REQUEST FOR COMMENTS FROM ALL INTERESTED PARTIES IN RESPONSE TO THE 27th
January and 3RD February 2023 CORRESPONDENCE.

WITTERING BROOK

DRAINAGE ATTENUATION POND

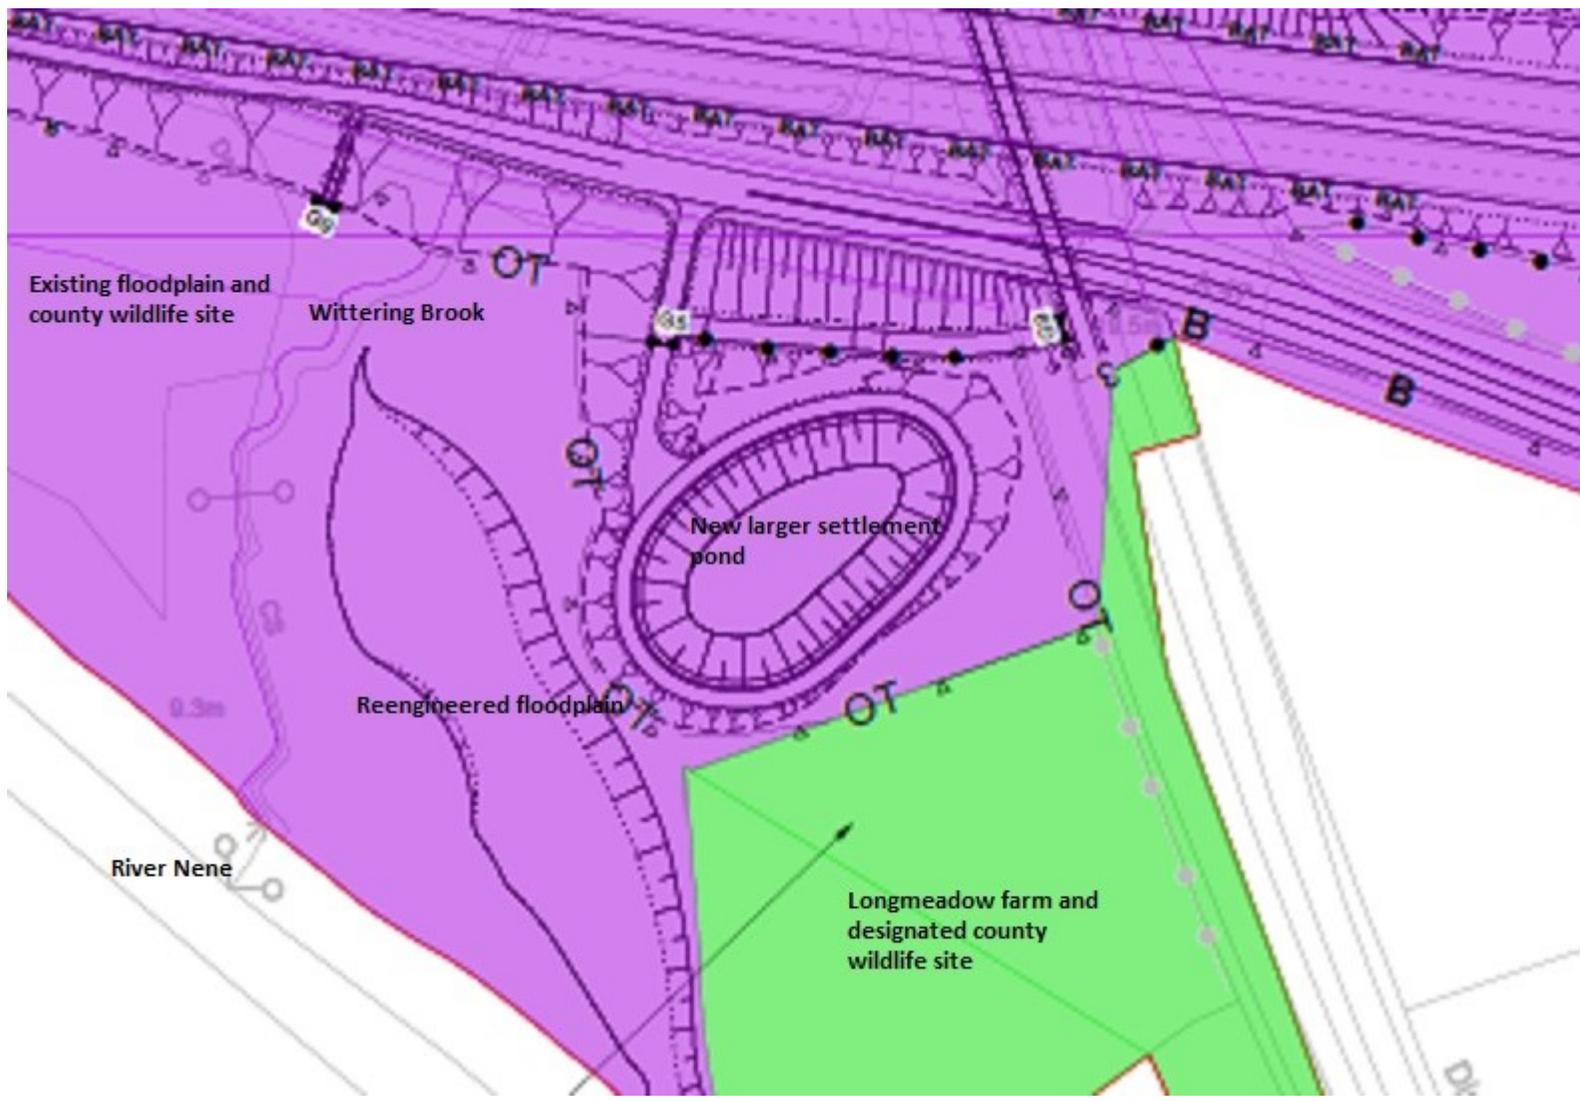
The Environment Agency appears to not answer the question but we hope the river Nene does not ever become so high it floods over the banks of the attenuation pond. The issue is that this is that the waste water contains traces of heavy metals, salt and hydrocarbons and potentially anything that leaks from a major road traffic incident. This will all settle out in the attenuation pond but it is right next to 2 watercourses and a reengineered floodplain. The contaminants will tend to leach out of the pond and, if the river floods, they will be flushed out in a single surge. Individuals, businesses, and farmers are prosecuted for the release of chemicals, fertilizer and hydrocarbons into waterways but National Highways are deliberately setting up a system where this will happen. It is unacceptable for National Highways (NH) to claim the proposed arrangement is an improvement in what is there presently. This road was built by the Romans when these issues were not high on the agenda. If the DCO had not been drawn so tightly to the road scheme on Homes England land, NH would have plenty of area to design the pond on arable land well away from the river. Can NH provide actual evidence of similar ponds near major water courses on the edge of floodplains?

PLAN VIEW
SCALE: 1:1000M

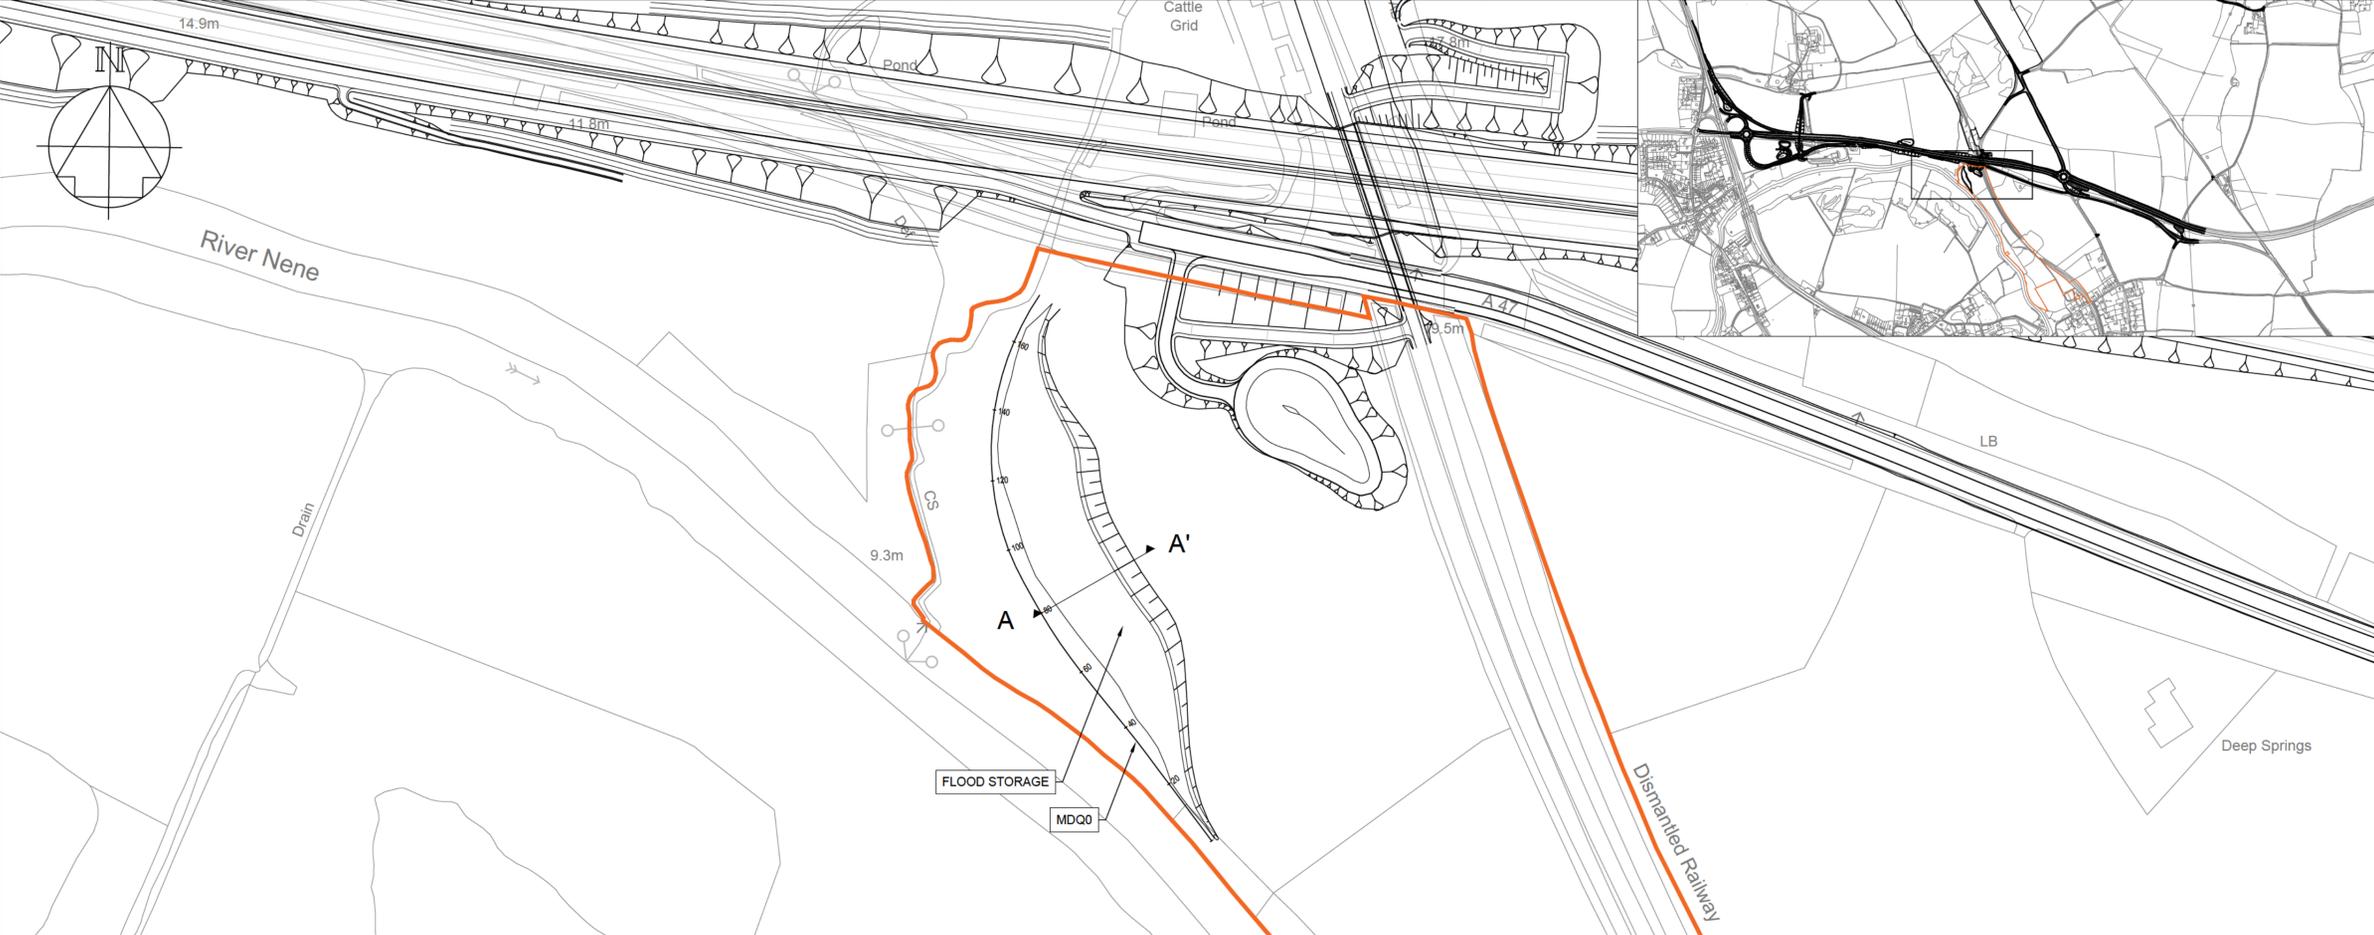
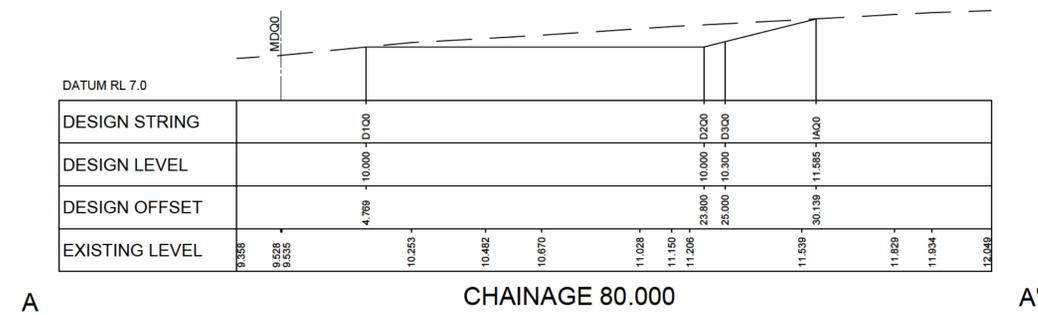
With the new pond design we found out that, due to costs, the power cables and services are now all to be over head cables running close to the river. During the Planning Inspectorate (PI) stage the NH lawyer confirmed these were going in ducting along the proposed WCHER route for both maintenance and egress. It was pointed out by the PI that, if left in place, these cables would be in the way of any decent mitigation on the slopes to protect the Nene Valley and River from light, air and noise pollution. This change in plan also threatens the breeding swans we have on the river as they are not very good at changing direction when taking off and the new power lines would be right in their flight path. NH and GT have offered up zero mitigation on our part of the County Wildlife Site (CWS). You cannot plant trees under power cables. NH claim they have a biodiversity net gain of 32% over the whole scheme, but it is at serious detriment to the CWS and that will never recover to its present biodiversity levels. NH have cut off the wildlife corridor from Sutton Heath via the disused railway and they are leaving the route to Wansford permanently compromised. I have been instructed to apply to Designated Funding for mitigation, but that's now short of money as they propose to spend at least 250k on moving a heritage building out of the community, plus a cycleway in Nene Park Trust that was rejected by the local community.
